City of Portland, Maine - Building or Use Permit Application
 389 Congress Street, 04101 Tel: (207) 874-8703, Fax: (207) 874-8716

Permit No: 05-1572	Issue Date:	CBL: 167 F006001
------------------------------	--------------------	----------------------------

Location of Construction: 75 Illsley St	Owner Name: Dimajo Clorinda Heirs	Owner Address: 75 Illsley St	Phone:
Business Name:	Contractor Name:	Contractor Address:	Phone:
Lessee/Buyer's Name	Phone:	Permit Type: Change of Use - Dwellings	Zone:

Past Use: Single Family Home	Proposed Use: Two Family Home/ Renewal of expired permit #020396	Permit Fee:	Cost of Work: \$0.00	CEO District: 4
Proposed Project Description: Two Family Home -Renewal of expired permit #020396		FIRE DEPT: <input type="checkbox"/> Approved <input type="checkbox"/> Denied	INSPECTION: Use Group: Type	
		Signature:	Signature:	
PEDESTRIAN ACTIVITIES DISTRICT (P.A.D.)				
Action: <input type="checkbox"/> Approved <input type="checkbox"/> Approved w/Condition <input type="checkbox"/> Denied				
		Signature:	Date:

STAIR LANDING FRAMING DETAIL

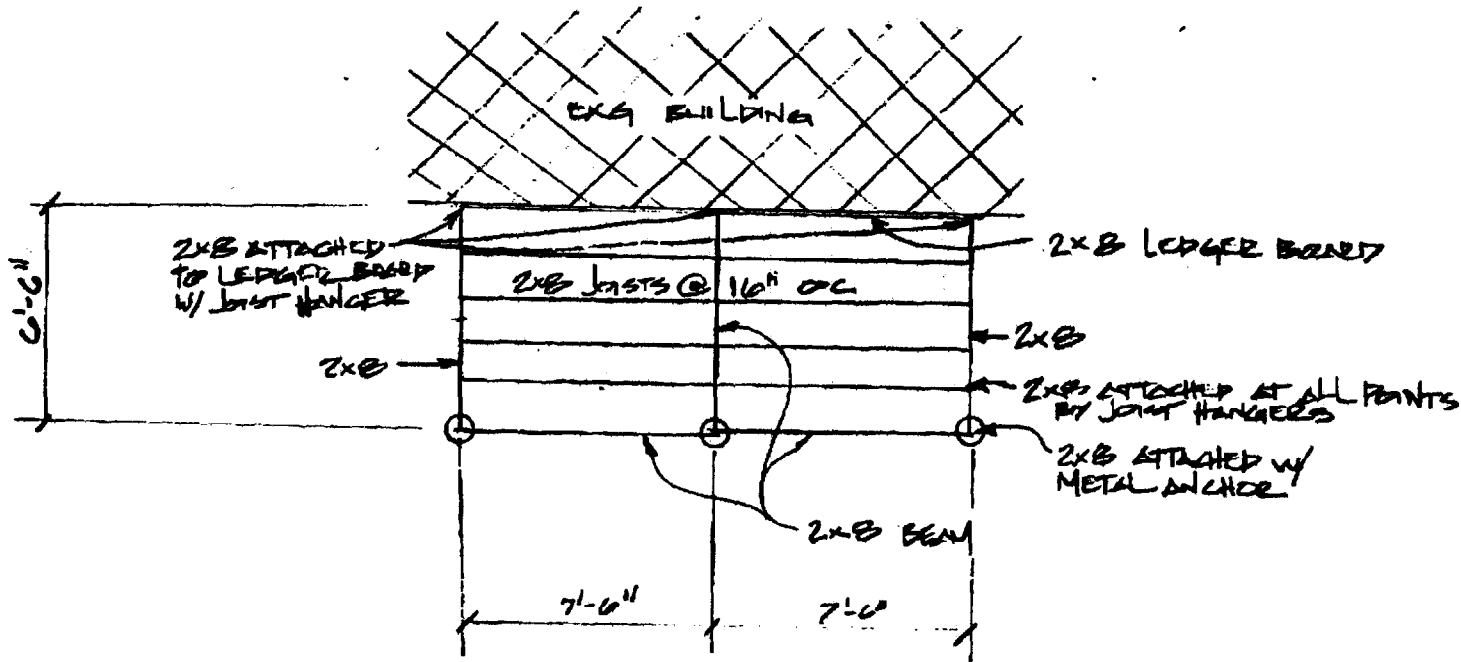
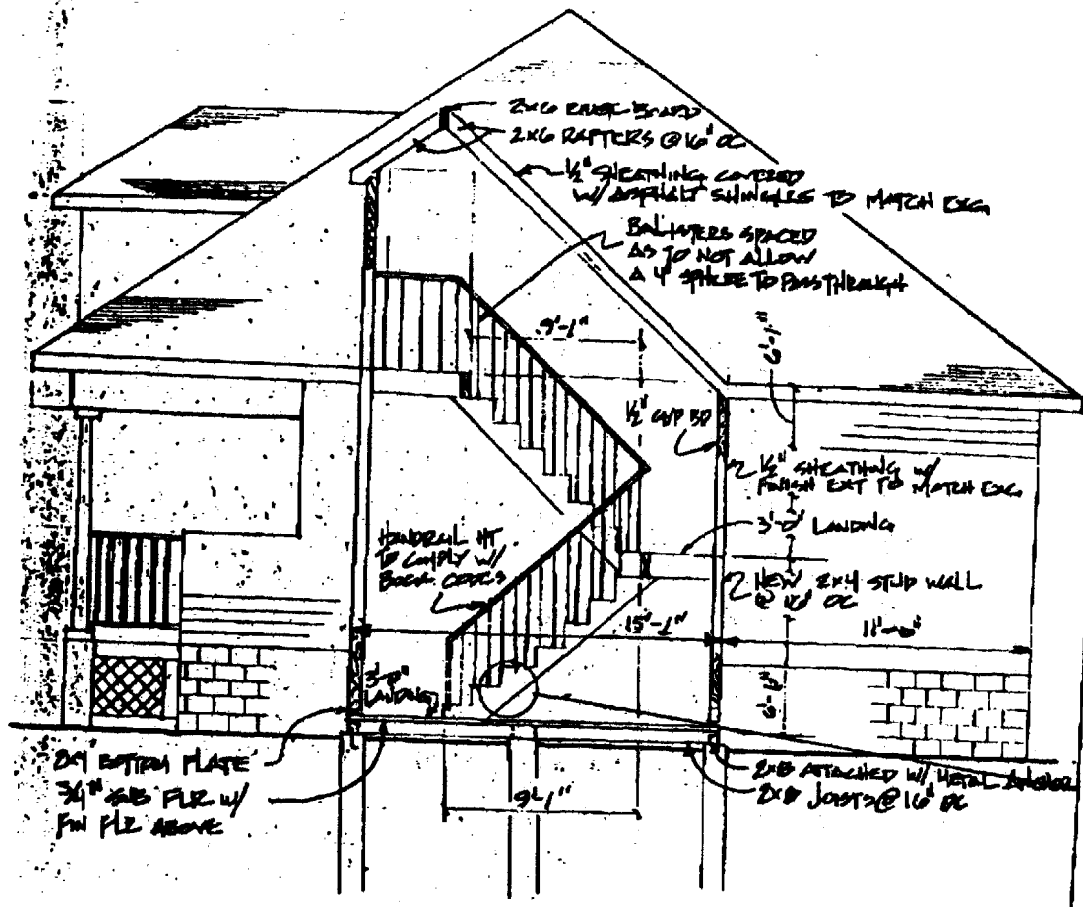
Comments:
10/27/2005-l Dobson: I have enclosed all of the original paper work from file and attached it to this permit. Routed it to Marge. LJD Charged 30 dollars for renewal. Fees paid on original permit.
11/16/2005-jmb: Left vm w/John D. To verify no changes and to inform the code has changed and there may be some additional requirements.
11/21/2005-jmb: John D. Called, reviewed new code requirements, he will submit new floor plan & rafter detail on the stair roof. Discussed fire penetrations, type X on the wall separating the stair & dwelling, insulation factors & headroom in the bathroom.
01/03/2006-jmb: Spoke w/John D. About the new revisions, still need stair detail, headroom issues in unit. He will re-submit
01/25/2006-jmb: John D. Submitted revisions, ok to issue
